I have received a revised layout from the client's engineer (attached). The base of the soakaway has been raised so that sufficient capacity is available above groundwater, and the layout now matches the calculations. Based on this revised drawing, and the previously submitted calculations and details I am happy to recommend the discharge of condition 3.

Engineers Comments Regarding Condition 3- Surface Water Drainage Design

© This drawing is copyright It may not be copied or reproduced without written authority			
Scale	As shown	At original	A3
Drawing Number	2014/SK2		Revision -

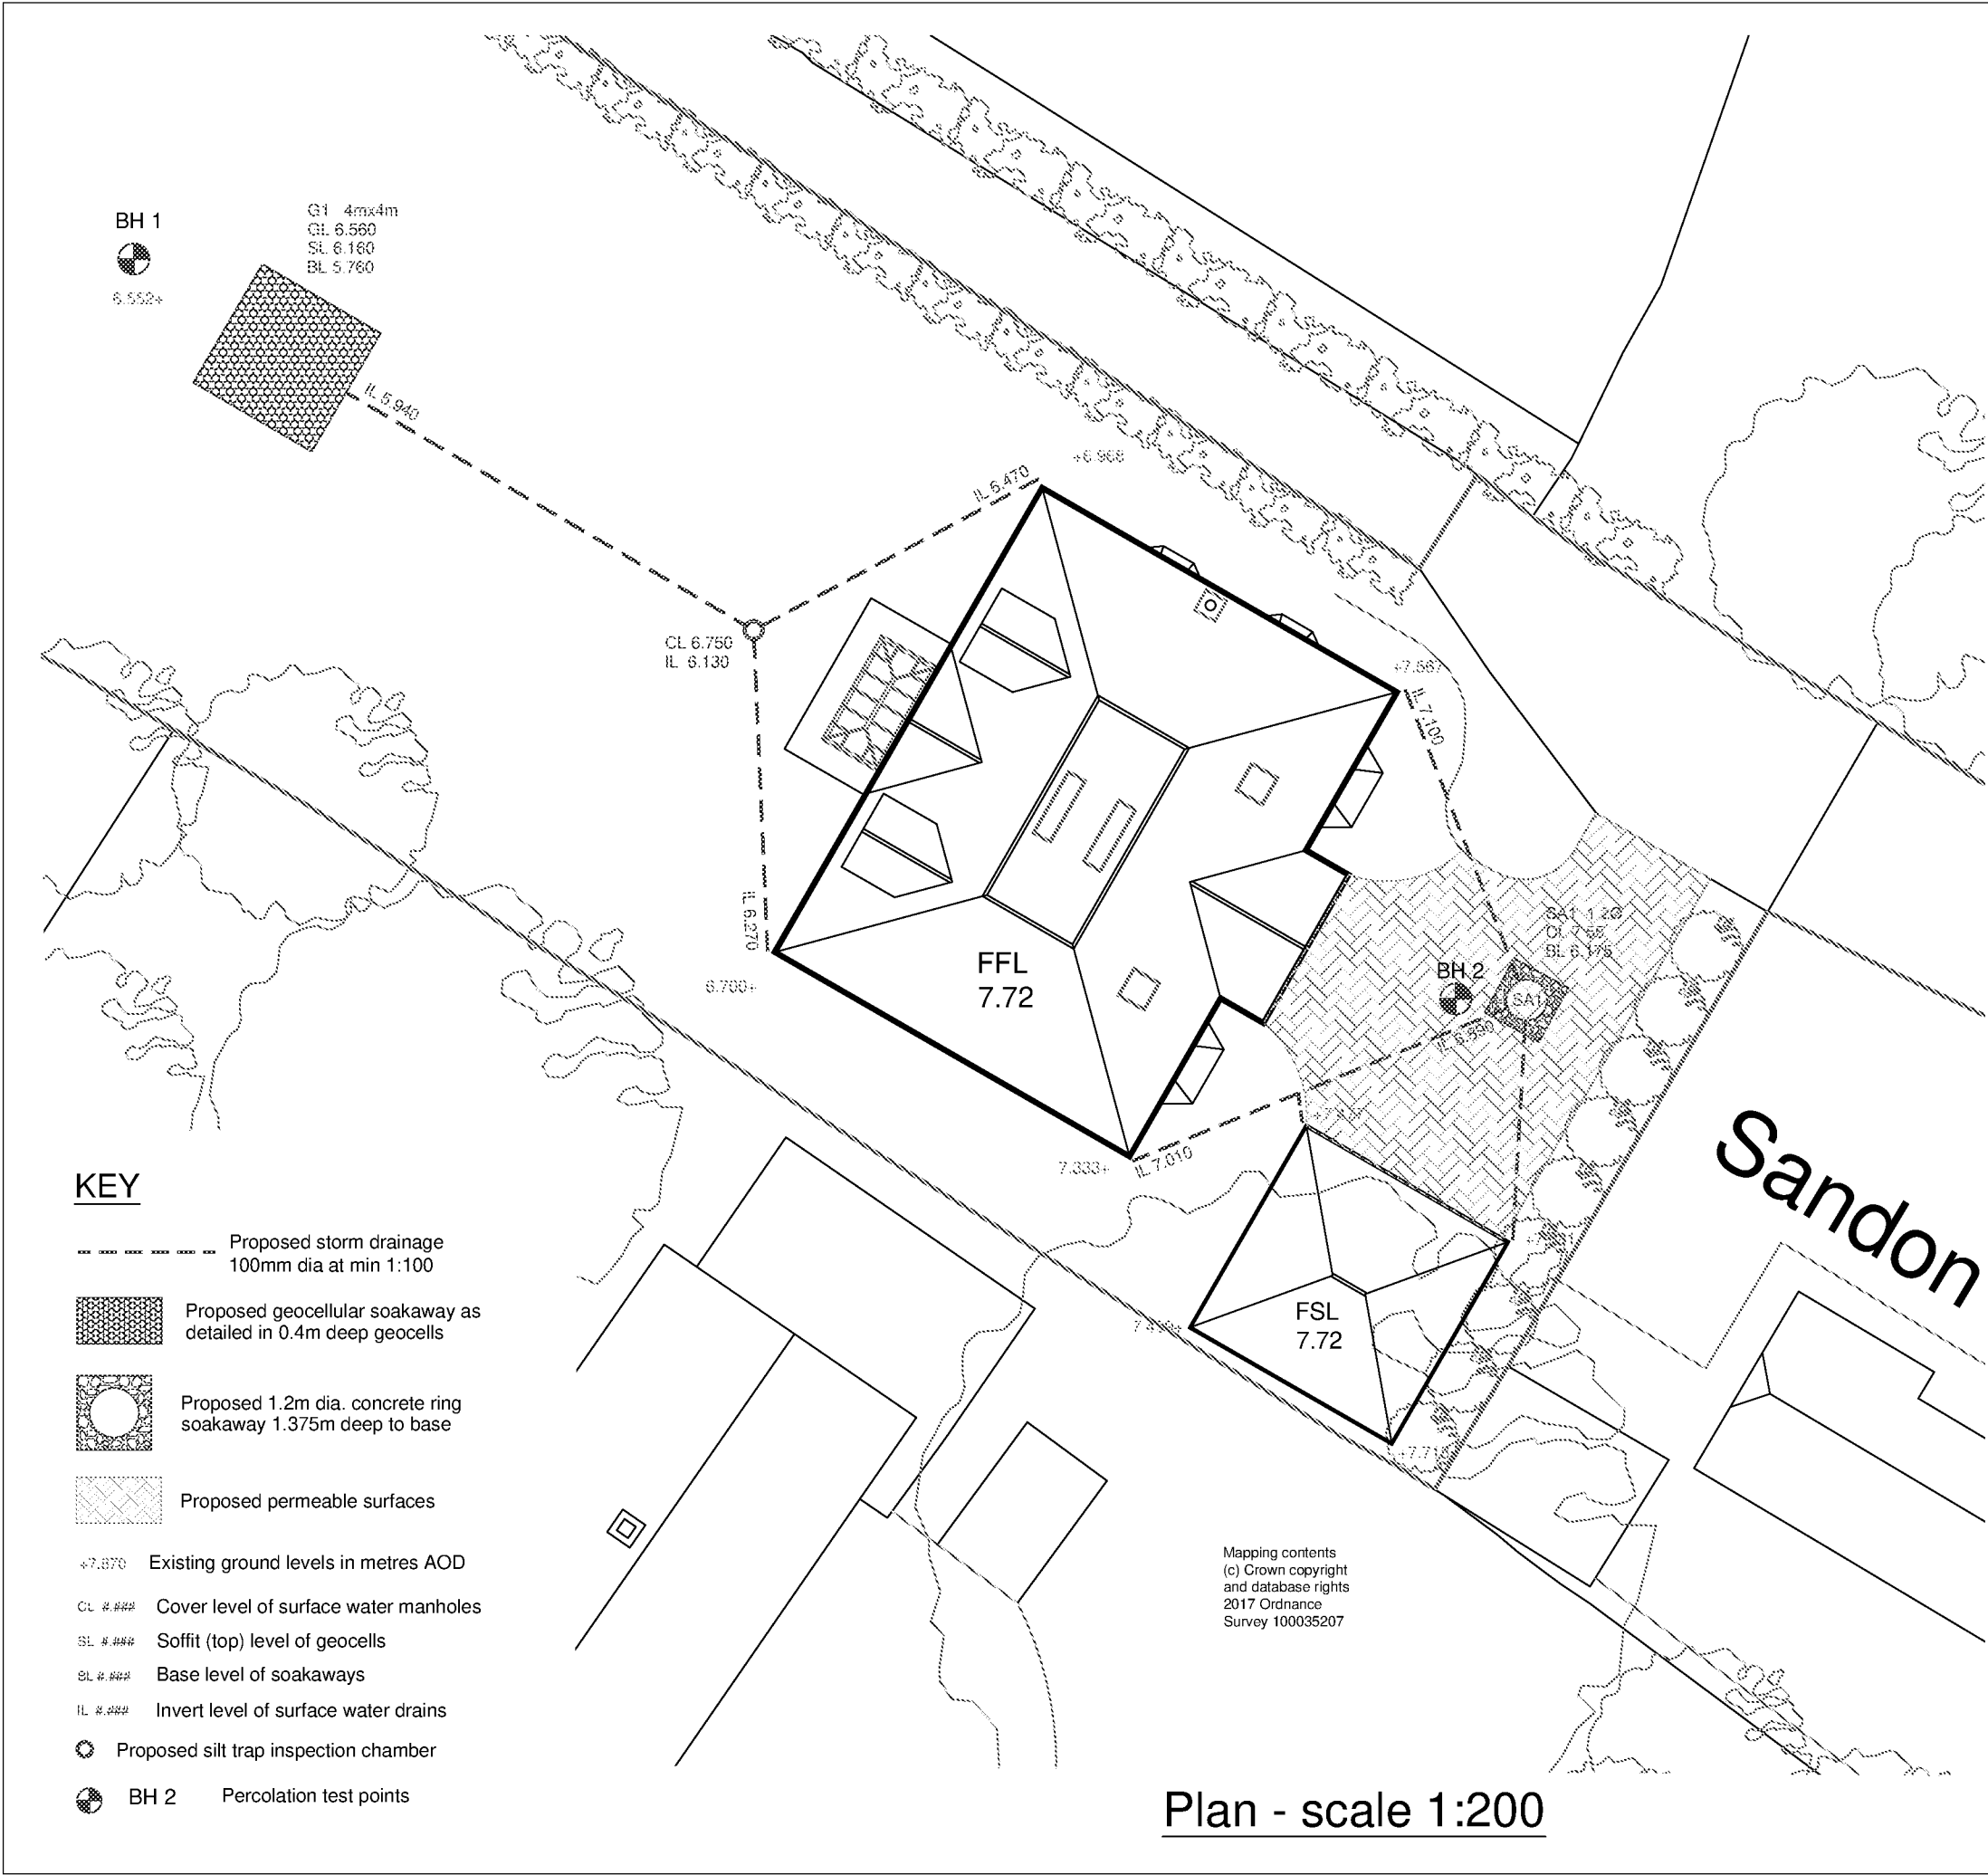
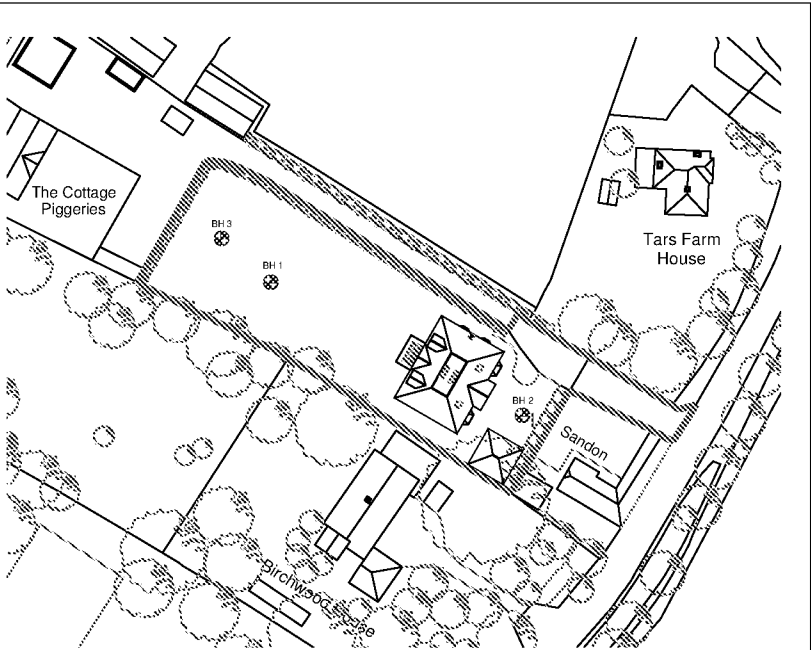
Winter groundwater monitoring and infiltration testing has been completed. The highest groundwater levels encountered were at 0.79m depth. It is unclear at which of the three monitoring locations that this peak occurred. Please can this be confirmed.

The soakaway that is proposed to be located in the rear garden has an invert level of 5.66m (0.9m below ground). The base of this soakaway must be located above the maximum recorded groundwater level, or adequate volume must be provided above the groundwater level.
